ARBORIST Memo

May 16, 2022

9017 SE 60th St.

You have asked me to prepare a brief memo in response to comments from Mercer Island City arborist John Kenney regarding two (2) trees located in the right-of-way (ROW) at the above referenced site. This memo should be considered together with a narrative report dated January 8, 2022, for this same property.

TOPOGRAPHIC SURVEY

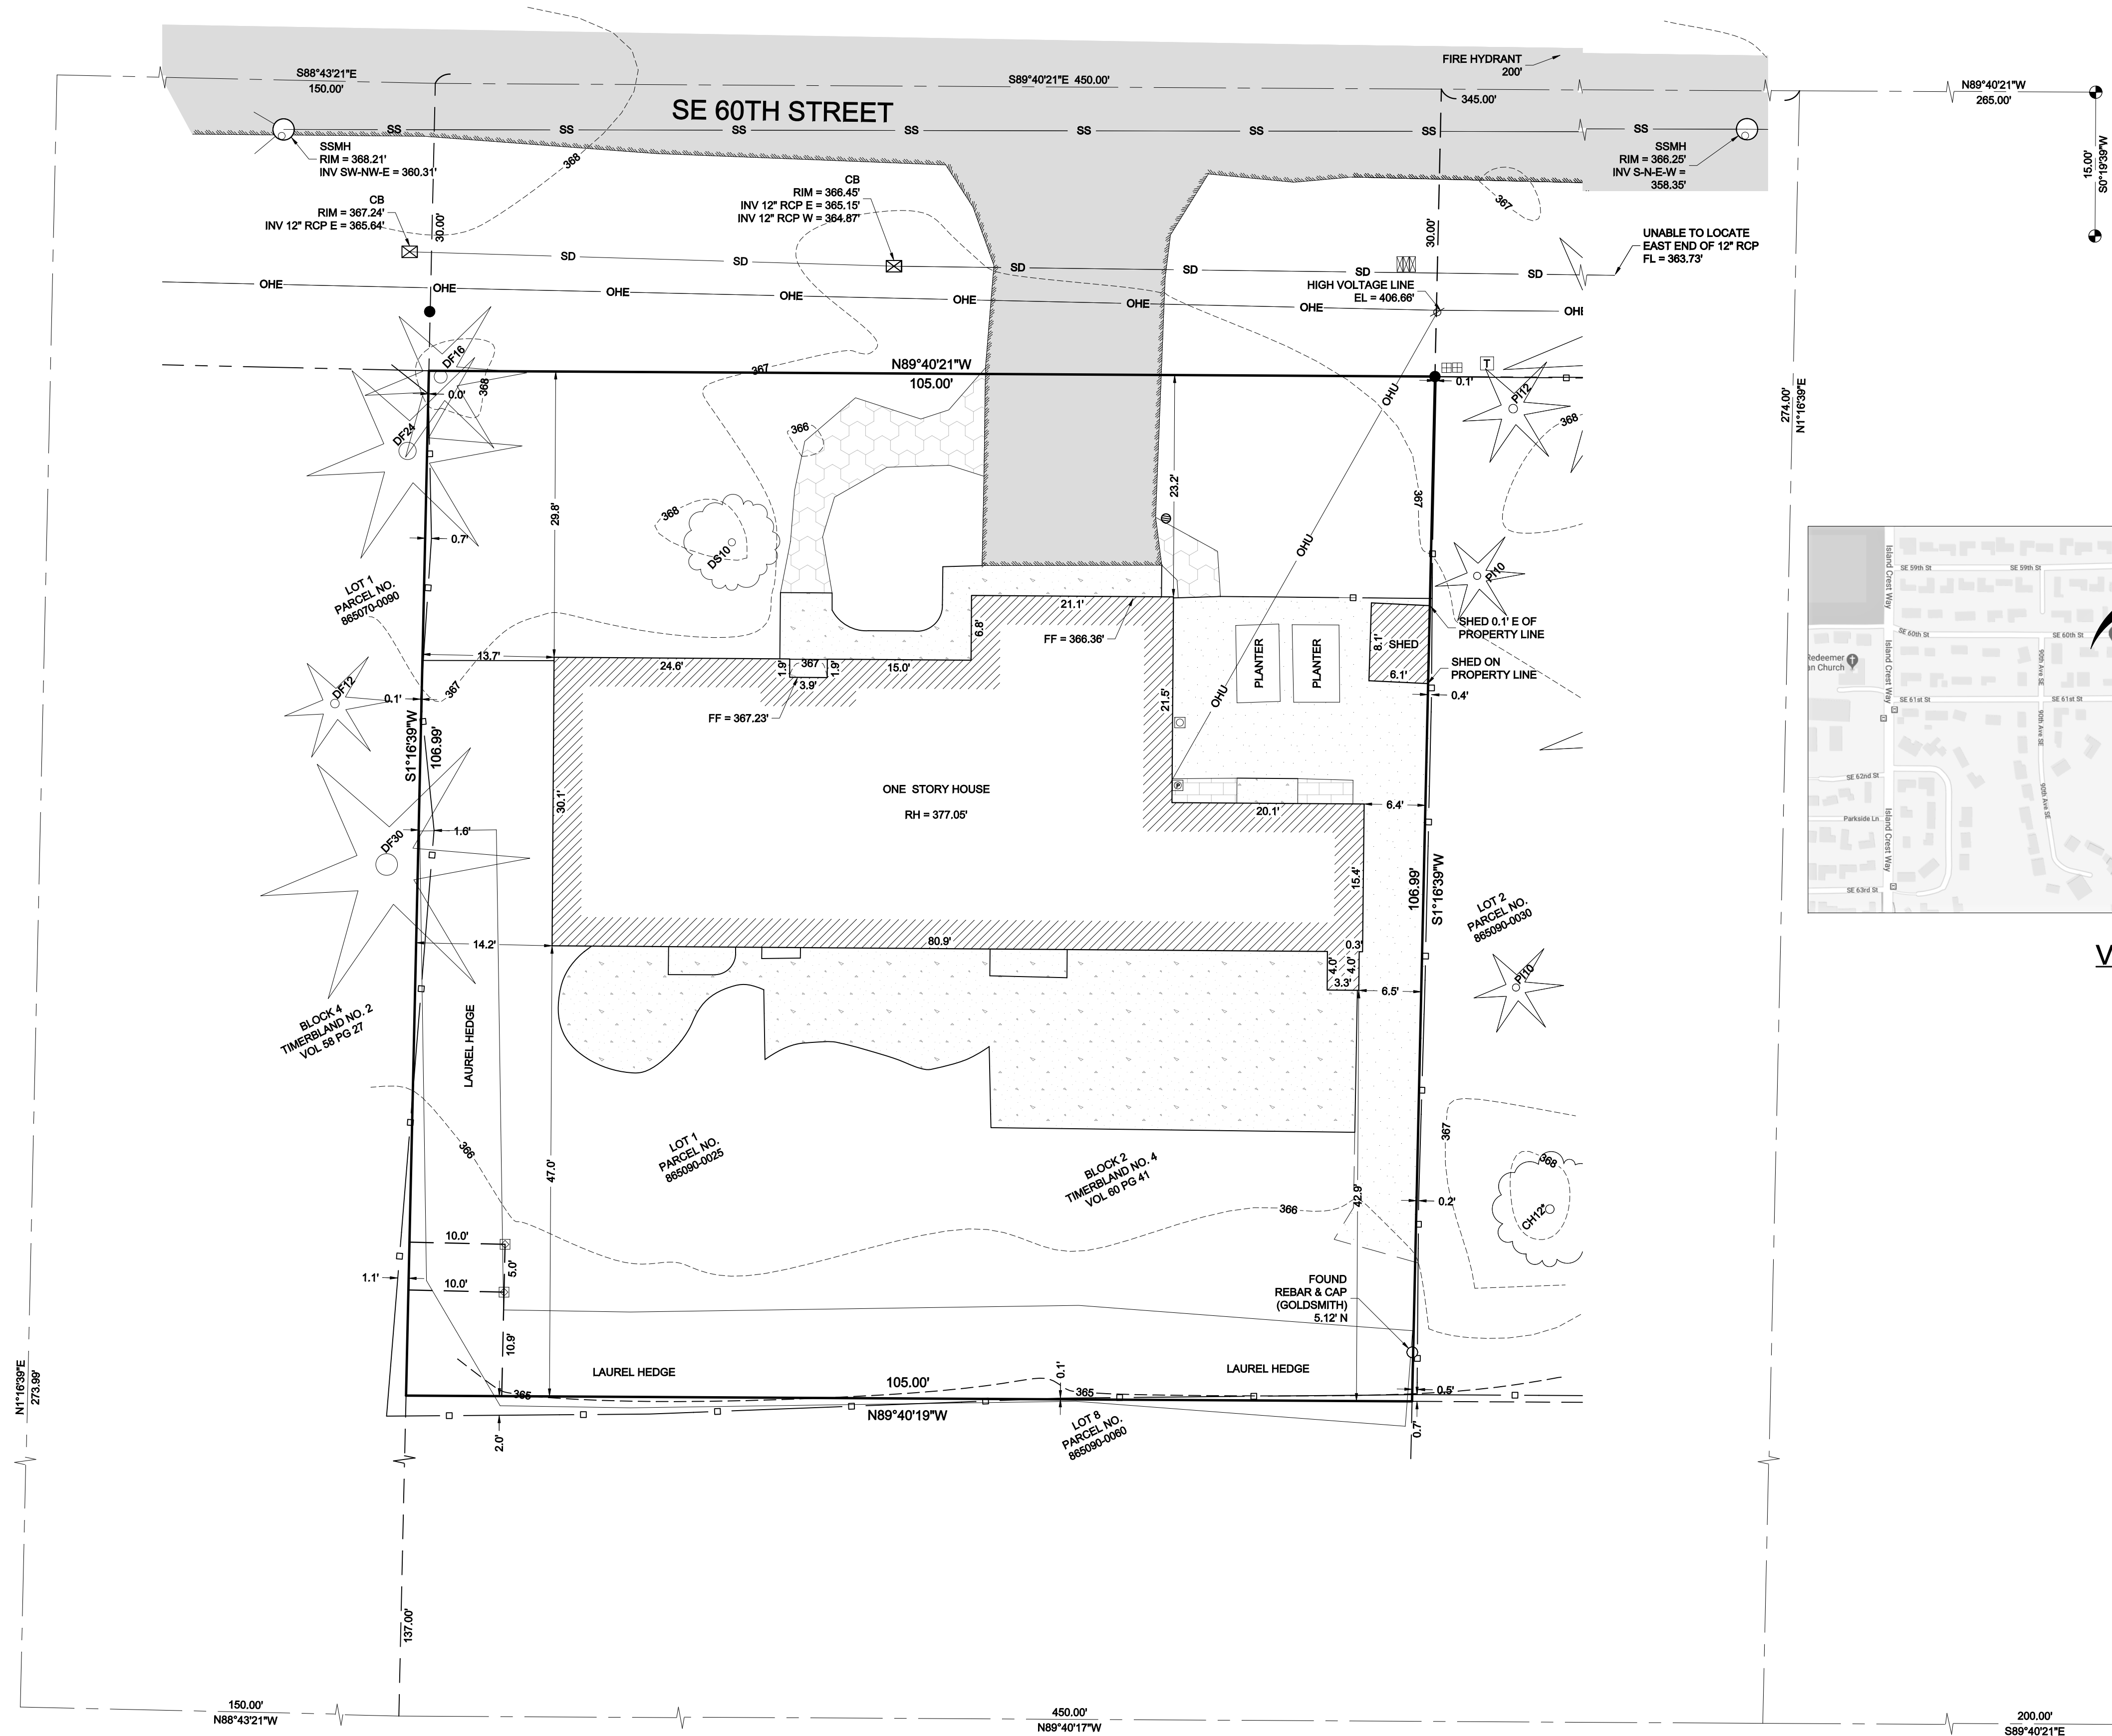
There is a Madrone Tree, *Arbutus menziesii*, that measured 4.97" DBH, rounded to 5.0" DBH. There are two (2) photos of the tree included below. The tree is leaning toward the street and the tree has a very advanced leaf fungal infection that has impacted 100% of the established foliage. There are new leaf buds beginning to open but they will be infected with the same fungal pathogen. The tree has landscape value and could possibly be nursed back to health by beginning a leaf fungal abatement program. It would not be unreasonable to remove the tree due to its current condition and to the fact that the lean cannot be corrected; the lean will become more problematic over time with regards to any risk of future failure with impact to the street, and pedestrian use. If you decide to remove the tree due to its structural lean and due to advanced defoliation, you will be required to plant one tree as near as possible to the current tree's location. If you retain it, the Tree Protection Fencing detailed for Tree #1 will also provide protection for this Madrone tree.

The second tree is a Laceleaf maple, *Acer palmatum dissectum*. This tree measured 8.0" diameter, said measurement taken just above grade, at the apparent graft mark. This tree has very good landscape value and is well worth the effort to protect and preserve it. Protection for this tree would include Tree Protection Fencing at its dripline radius. The dripline is 5' east and west and 6' north and south. Protection and mitigation measures are as detailed in the original report dated January 8, 2022.

The City requires that all trees located in the ROW be retained and protected, if possible. John Kenney detailed that no additional gravel be added around these two trees located in the ROW. Currently there is lawn sod between the street asphalt edge and the planting bed that contains

the two offsite trees. Extending the Tree protection Zone for these two trees to include as much of the grass area as possible would be beneficial.
